From: Joseph Freegard
Sent: 01 September 2022 16:27
To: Dave Askwith
Cc: Planning; Michael Tagg; Jamie Wignall
Subject: 22/01045/FUL

This application for 'Change of Use of Agricultural Buildings into Two Dwellings with Associated Building Operations' at Forwood Farm on Wood Lane in Treswell is a re-submission of application 21/01255/FUL. Conservation objected to application 21/01255/FUL for the following reason:

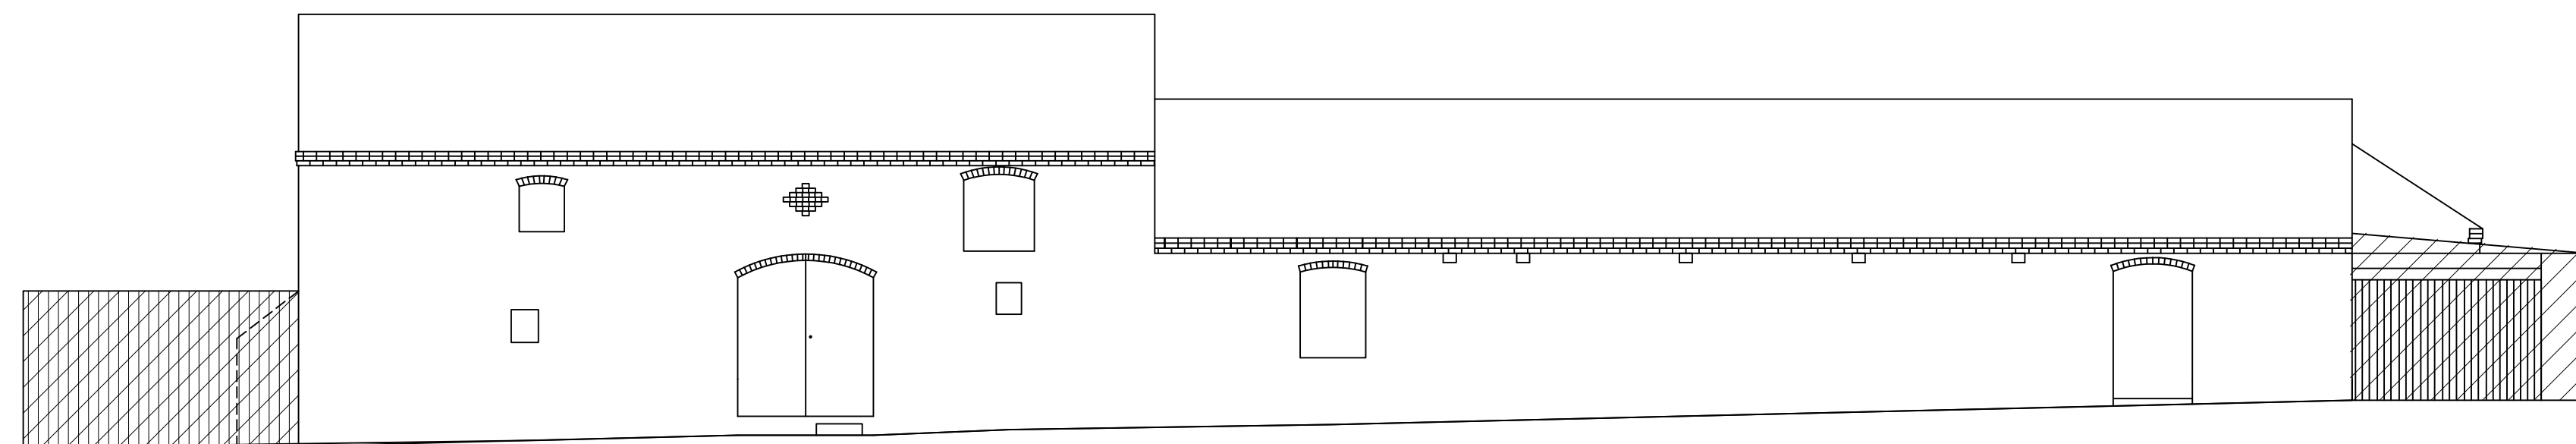
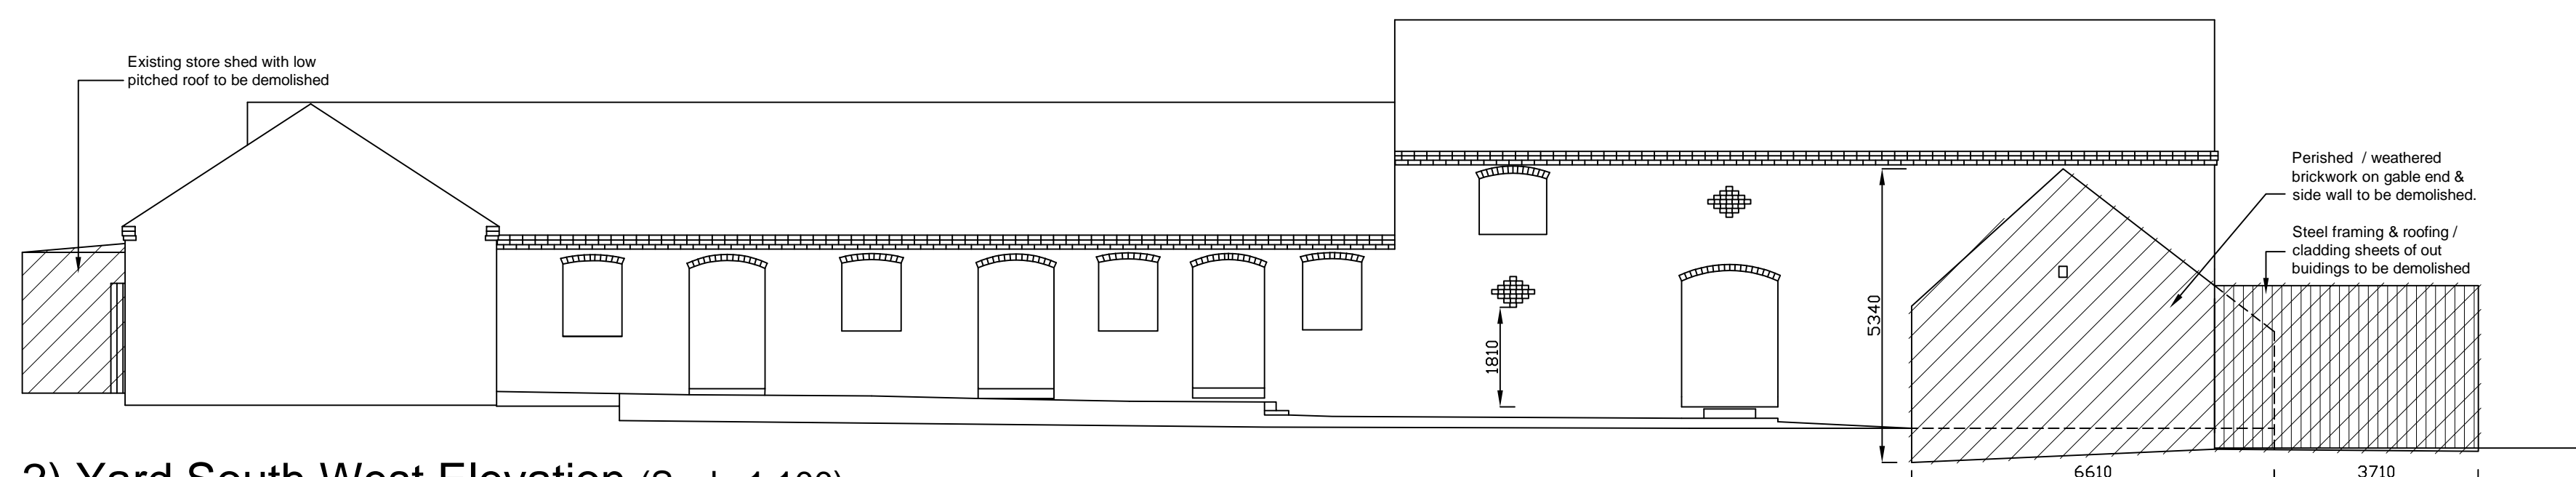
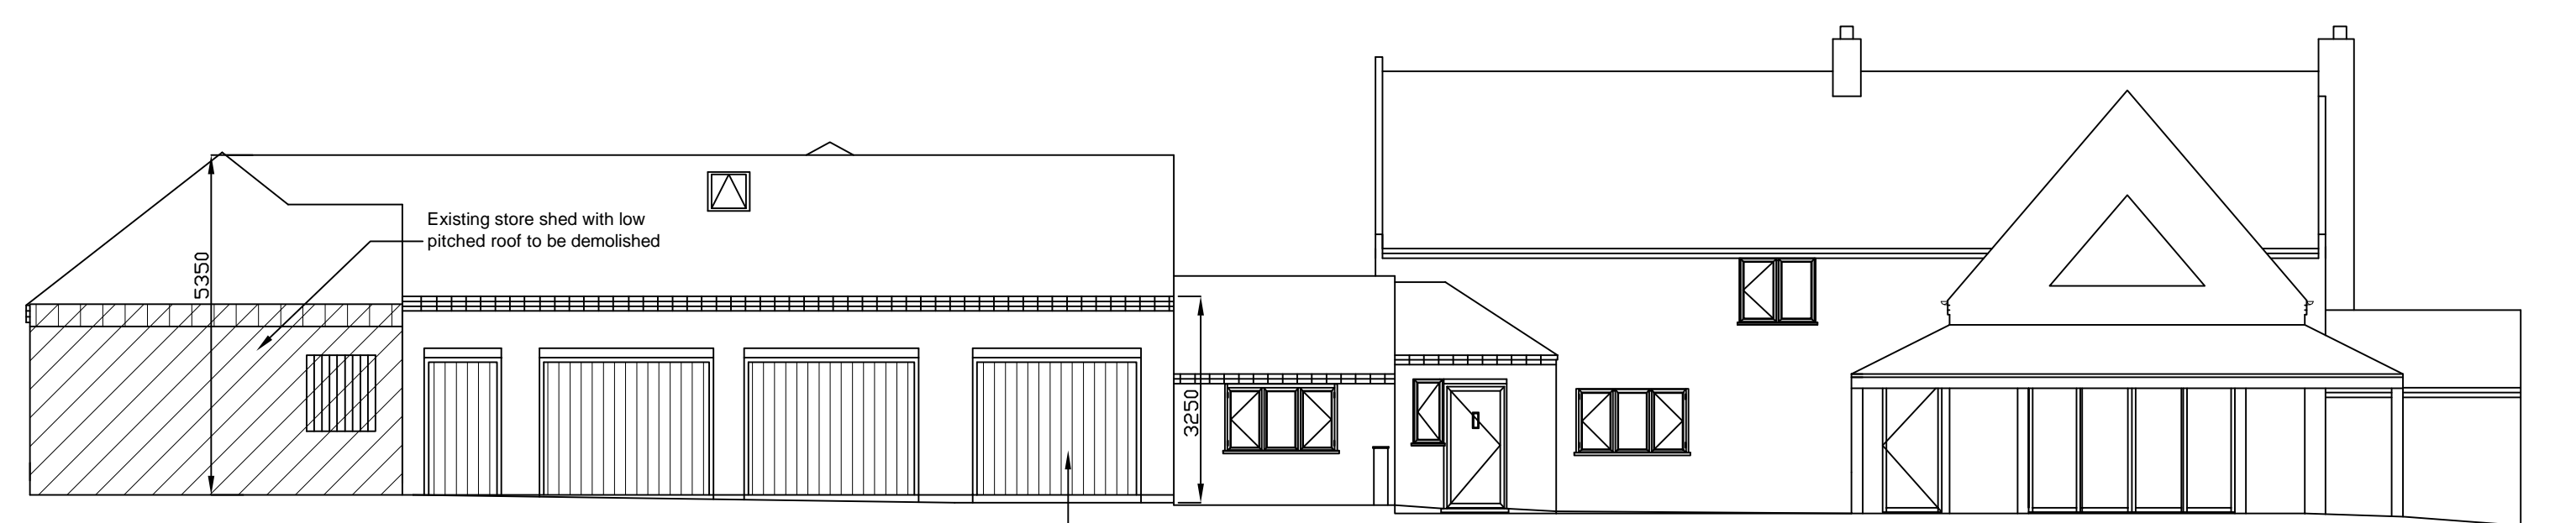
This current application still proposes the demolition of the cart sheds and the part demolition of the stables. The cart sheds are proposed to be replaced by a larger single storey garage building in reclaimed red brick with a pitched clay pantile roof. Three vertically boarded timber garage doors and two vertically boarded pedestrian doors are proposed to the north east facing elevation, and these would have segmental arches above. All other elevations would be blank, and the structure would have three rooflights and corbelled eaves. The stables are now proposed to be replaced by a one and a half storey structure rather than a two storey structure, which would also be in reclaimed red brick with a pitched clay pantile roof. The timber posts to the north west facing elevation would be replaced by a brick wall with timber boarded mock cartshed openings containing hopper style windows and a door. A mock cartshed opening and agricultural hopper style window are proposed to the south west facing gable, and three agricultural hopper style windows with shutters are proposed to the south east facing elevation. The structure would have eight rooflights, corbelled eaves and segmental arches to the windows and doors. Although the
